Installation of a standalone solar PV array, associated infrastructure, grid connection, access and landscaping

Land North Of Hill Farm, Hill Farm Lane, Duns Tew, OX25 6JJ

• Flood Risk Assessment 2640/FRA, produced by Halfren Water, dated November 2019, Version D1.

Title Fluvial Flood Risk Map

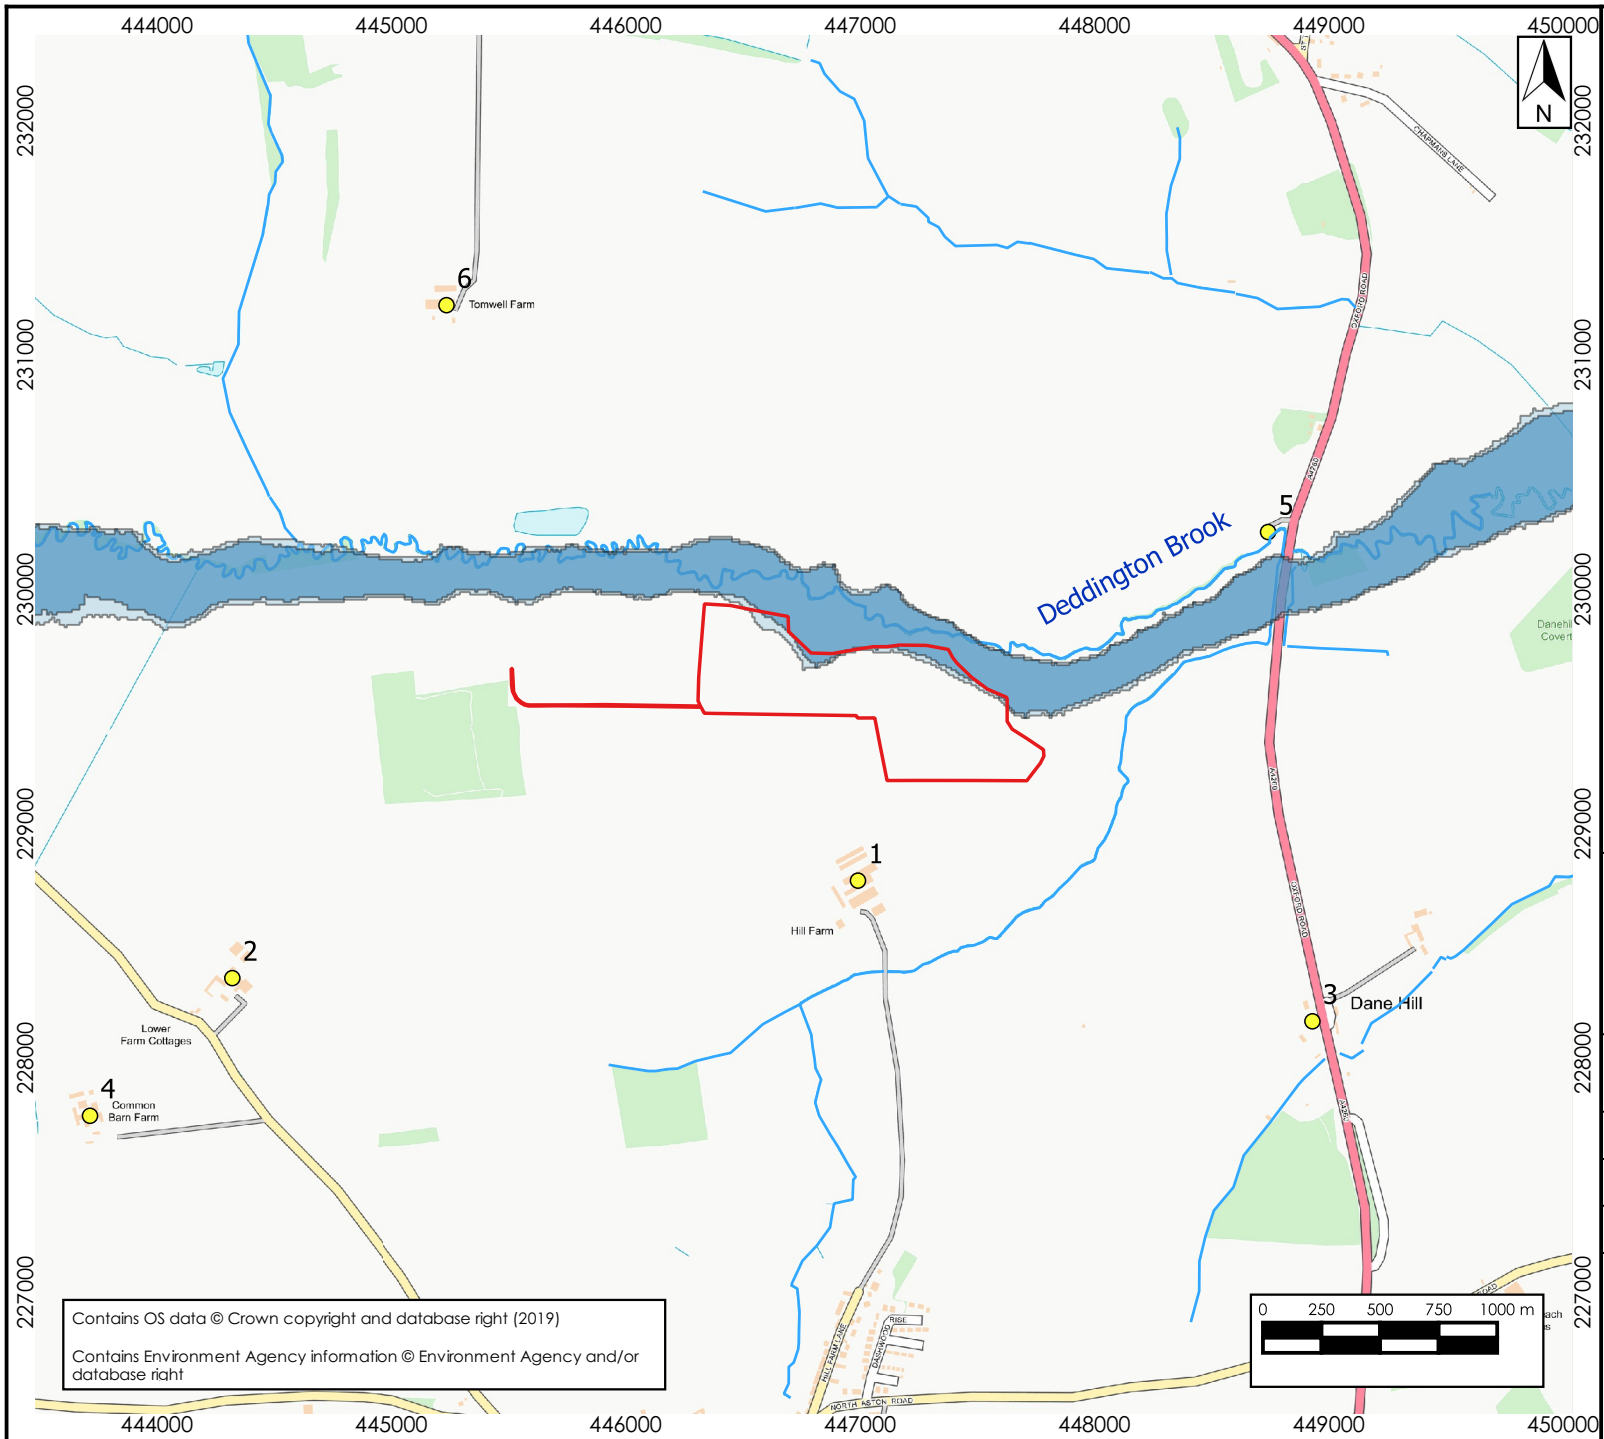
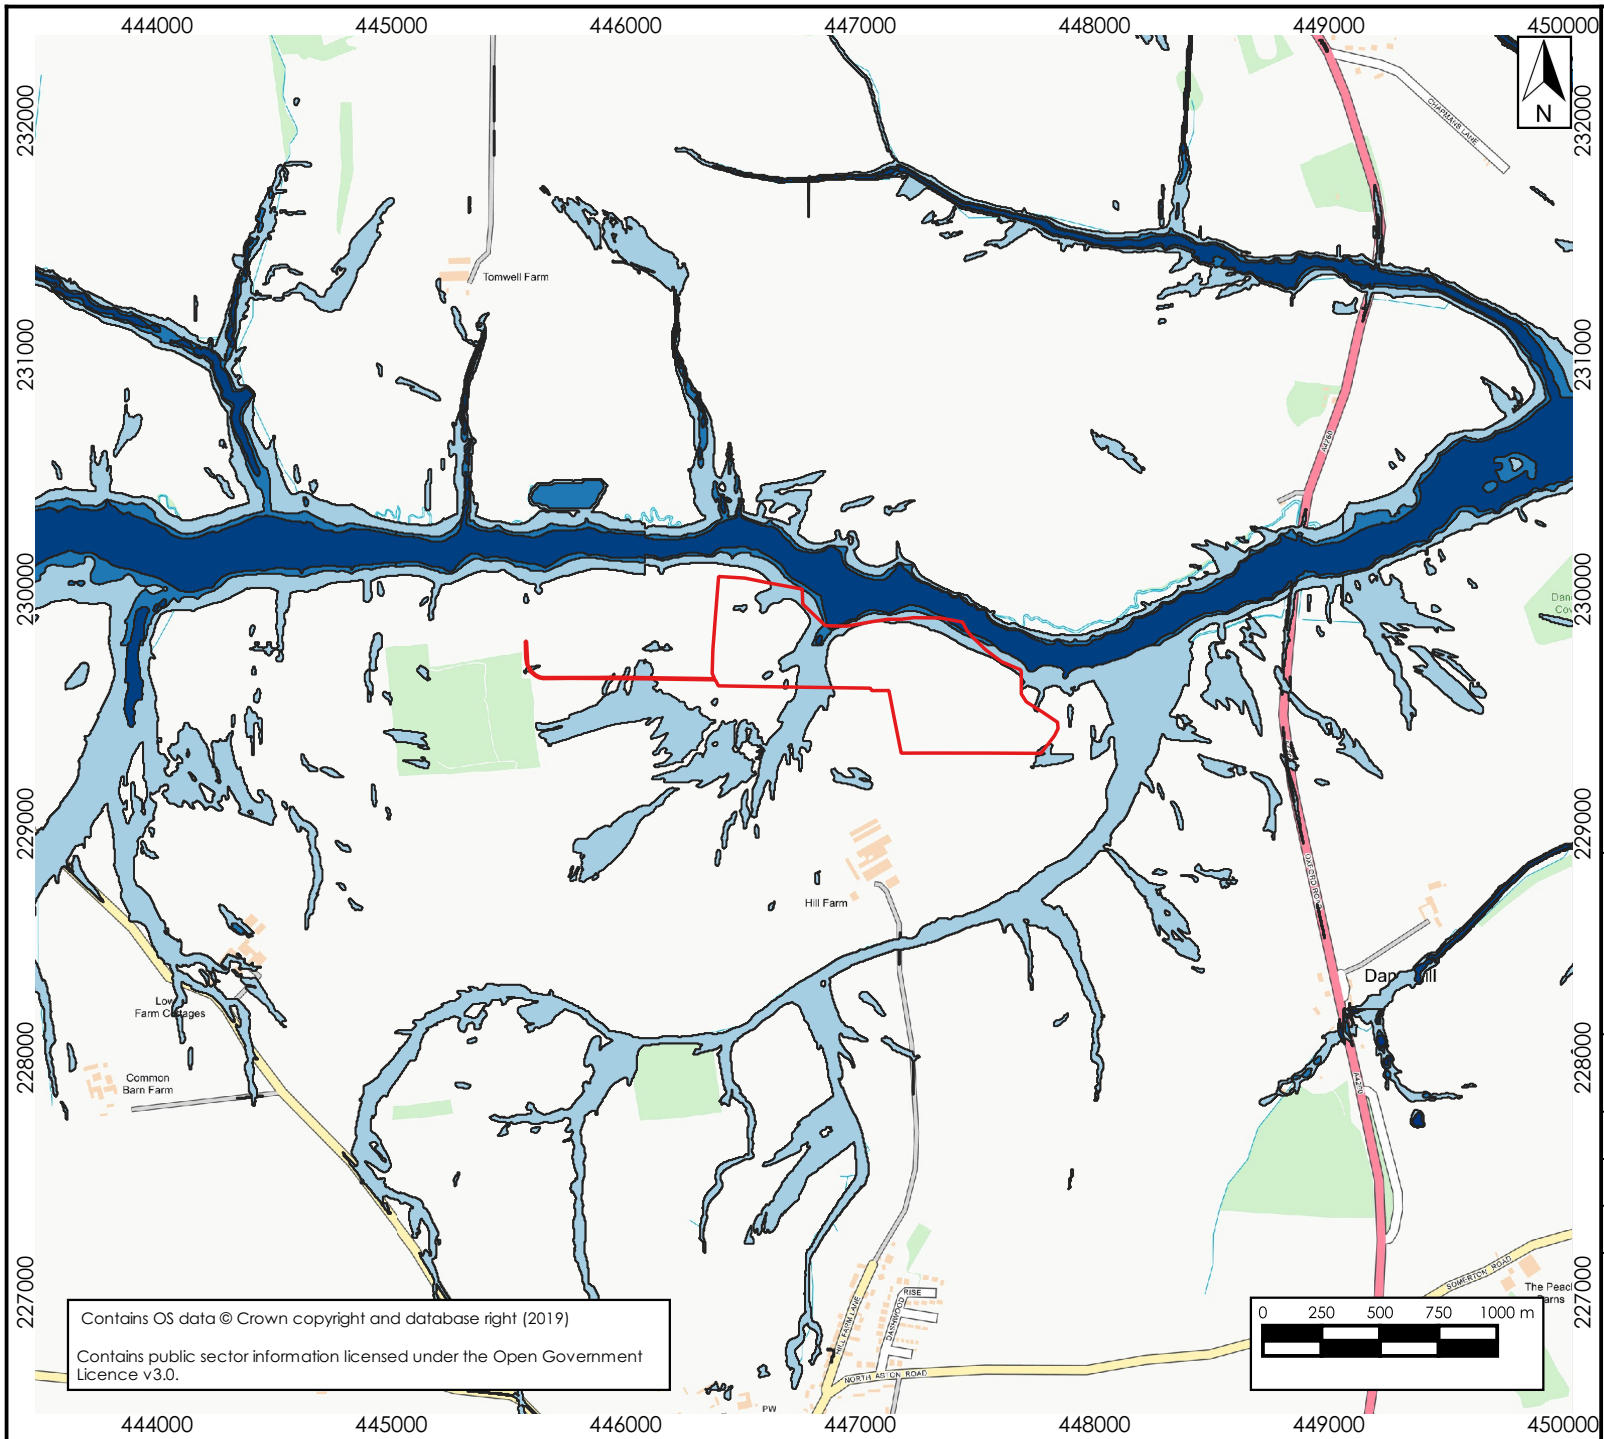
The submitted FRA does not comply with the requirements for site-specific flood risk assessments, as set out in paragraphs 30 to 32 of the Flood Risk and Coastal Change section of the planning practice guidance. The FRA does not therefore adequately assess the flood risks posed by the development. In particular, the FRA fails to:

- consider how a range of flooding events (including extreme events) will affect people and property;
- take the impacts of climate change into account.

Specifically, the applicant has not determined an accurate climate change flood level for the site. Based on current Environment Agency climate change guidance, a detailed assessment of climate change should be undertaken for the site. This will take the form of an updated hydraulic model. This will be based on the scale, vulnerability and flood

zones attributed to the site and development. The applicant should use relevant guidance to determine what would be a suitable <u>climate change allowance</u> for the site.

At present, based on best available flood data (JFlow), only a relatively small number of the total panels are to be located within flood zone 3. It is understood that the applicant plans to raise these above the estimated flood level to avoid an impact on floodplain dynamics. However, the flood level information in this locations is coarse, and further assessment should be made to increase the accuracy of the flood level. An updated climate change flood level for the site may mean that a greater number of the panels are situated within the 1% Annual Exceedance Probability (AEP) plus an appropriate allowance for climate change flood extent, and the height that these panels need to be raised to avoid the floodplain may also be affected. The climate change assessment should inform these decisions.

To overcome our objection, the applicant should submit a revised FRA which addresses the points highlighted above.
